January 23, 2019

Re: Tenant Improvement
4801 Lincoln Rd. NE 87109
Traffic Circulation Layout
Engineer's/Architect's Stamp 01-16-19 (F17D024A)

Based upon the information provided in your submittal received 01/23/2019, the above referenced plan cannot be approved for Building Permit until the following comments are addressed:

AS-1.1

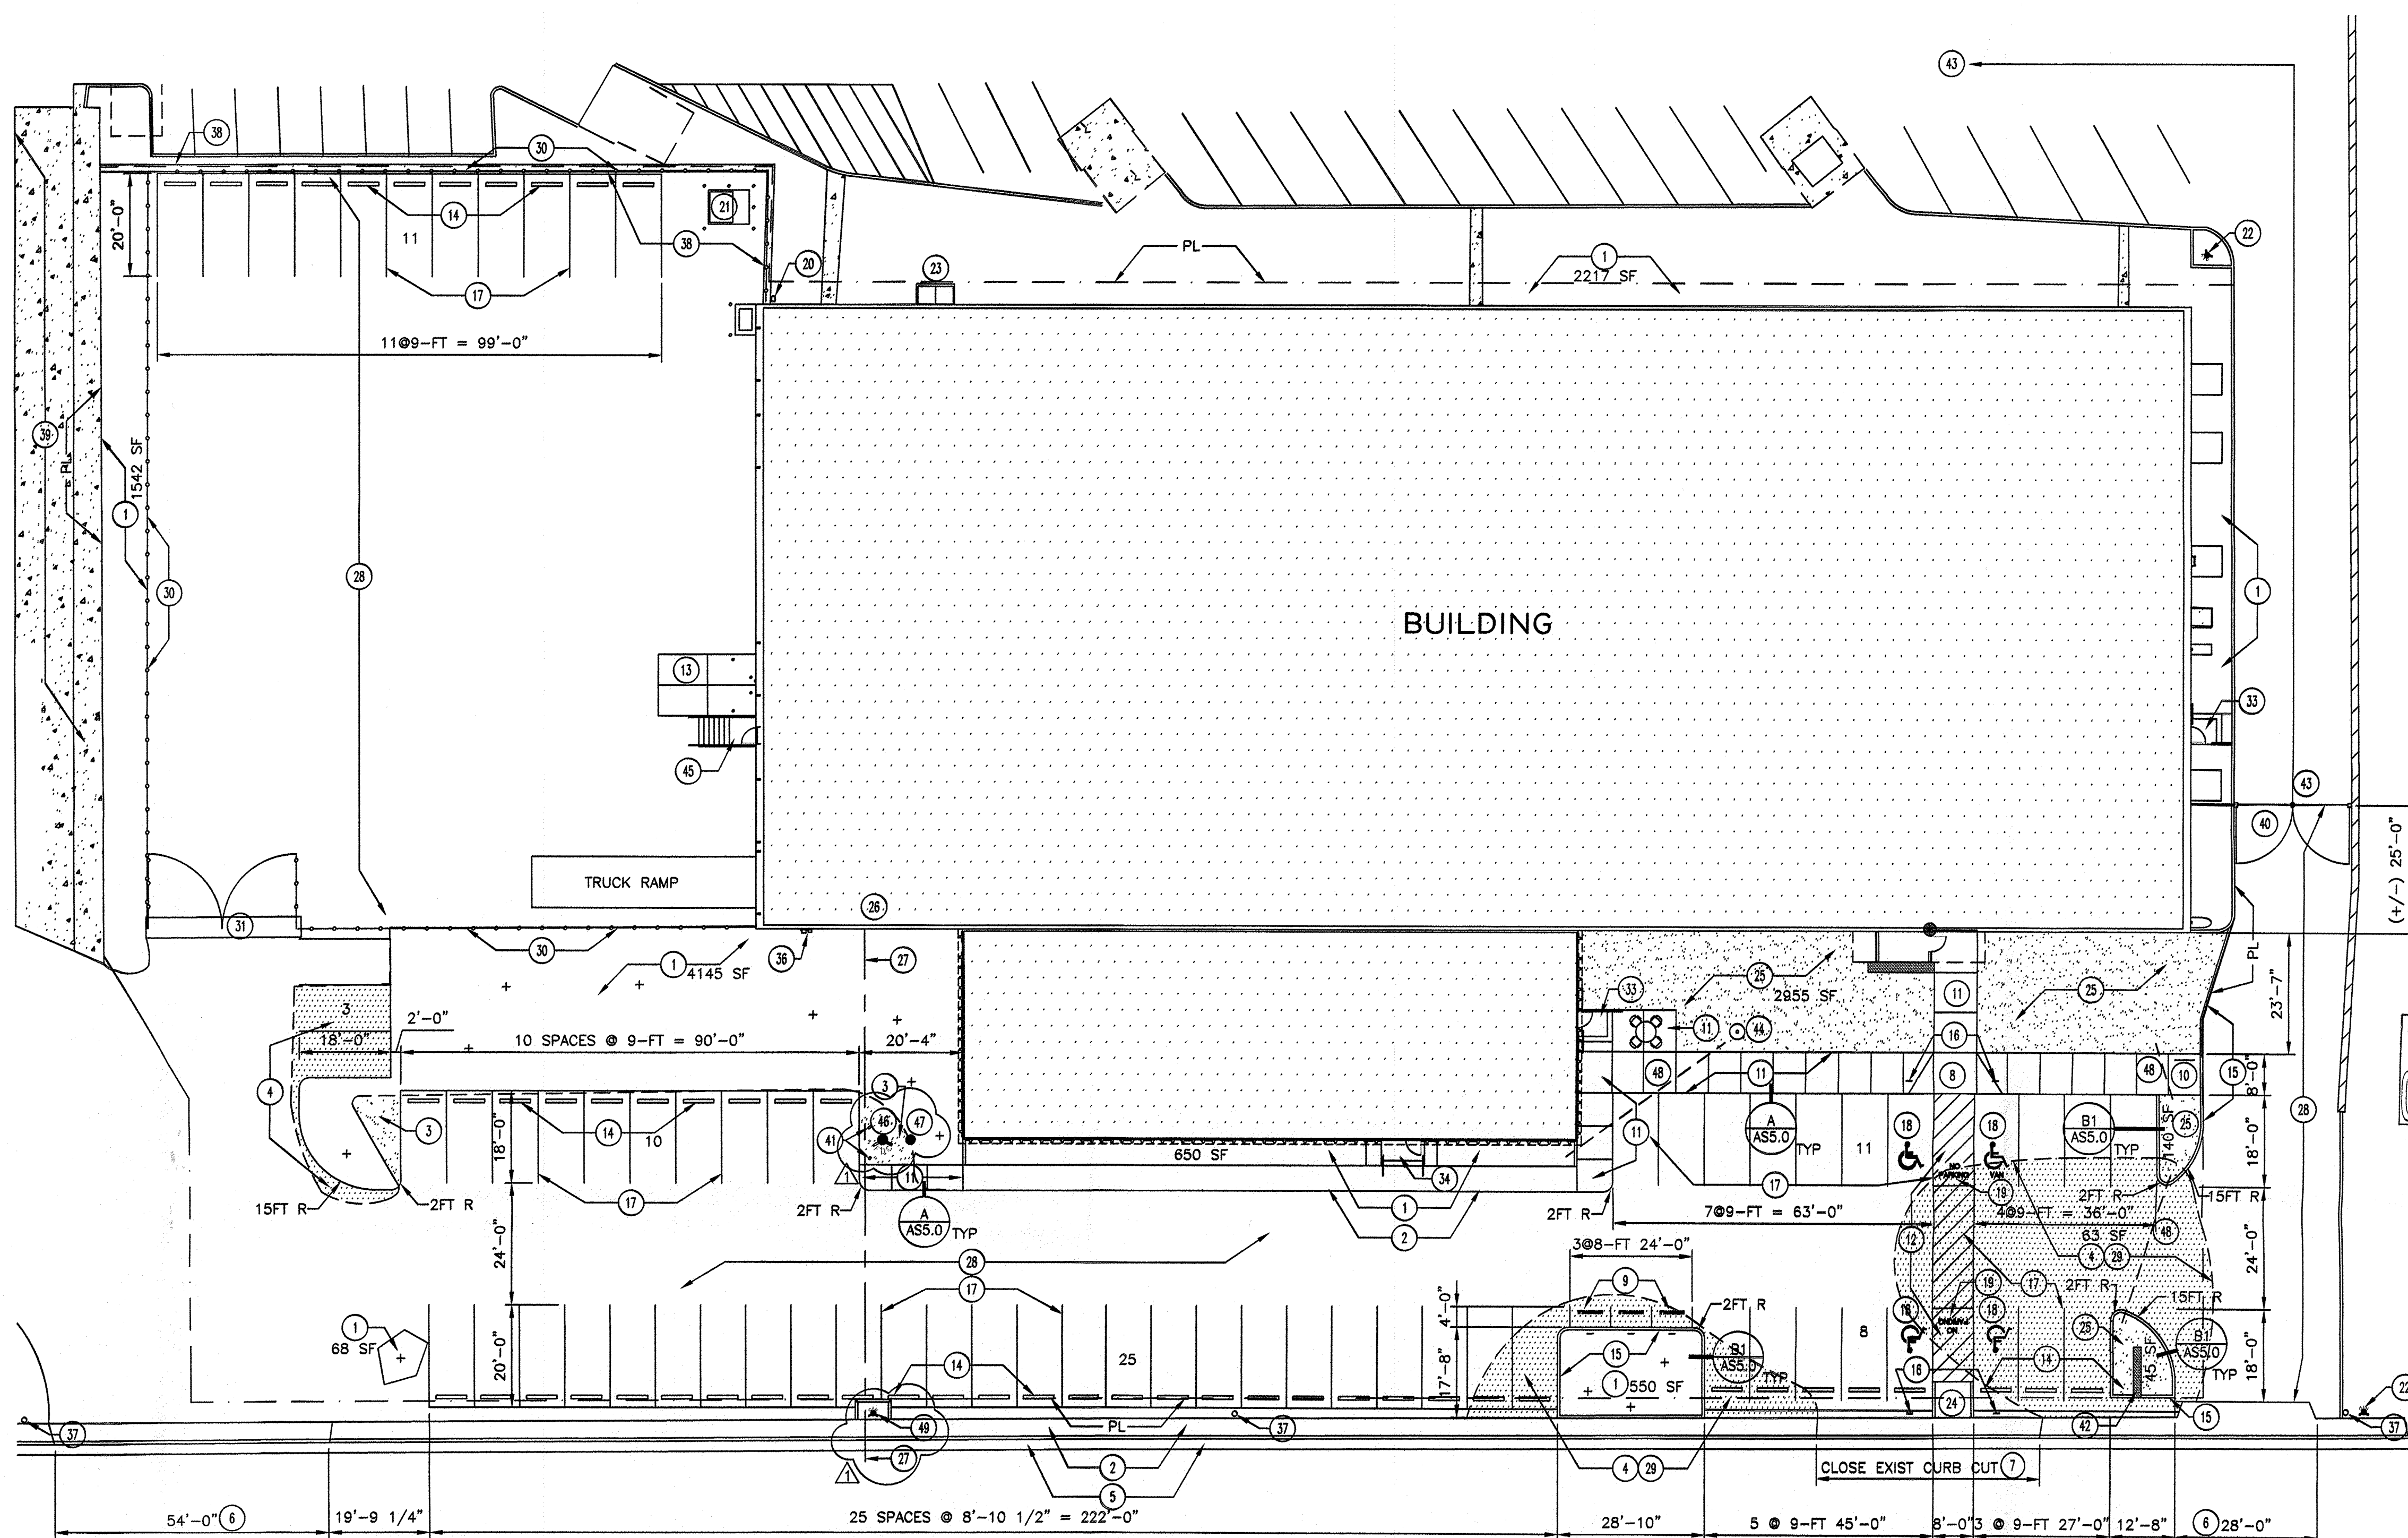
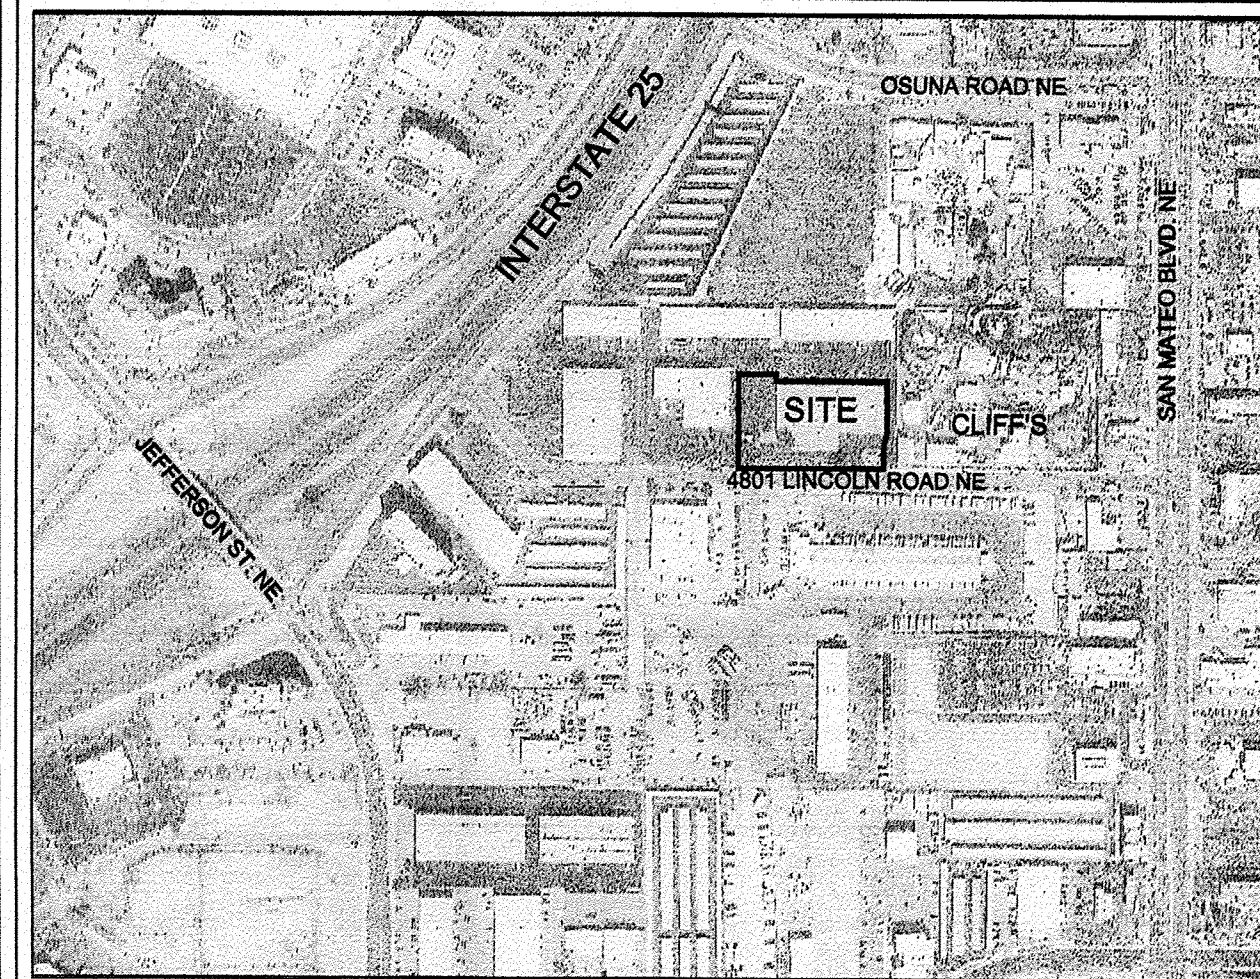
1. Please show a vicinity map showing the location of the development in relation to streets and well known landmarks.
2. List the number of parking spaces required by the zoning code as well as the proposed number of parking spaces including bicycle and motorcycle parking.

4. Please list the width and length for all existing and proposed parking spaces. Some dimensions are not shown.
5. The handicap accessible spaces must be a minimum of 8.5 ft. in width.

6. The handicap accessible spaces must include an access aisle. Van accessible aisles should be 8ft wide; all others should be 5ft wide.
7. The ADA accessible parking sign must have the required language per 66-7-352.4C NMSA 1978 "Violators Are Subject to a Fine and/or Towing." Please call out detail and location of HC signs.

8. The ADA access aisles shall have the words "NO PARKING" in capital letters, each of which shall be at least one foot high and at least two inches wide, placed at the rear of the parking space so as to be close to where an adjacent vehicle's rear tire would be placed. (66-1-4.1.B NMSA 1978)

9. Show all drive aisle widths and radii. Some dimensions are not shown.
10. One-way vehicular paths require pavement directional signage and a posted "Do Not Enter" sign at the point of egress. Please show detail and location of posted signs.

11. Provide a shared access agreement with adjacent property.
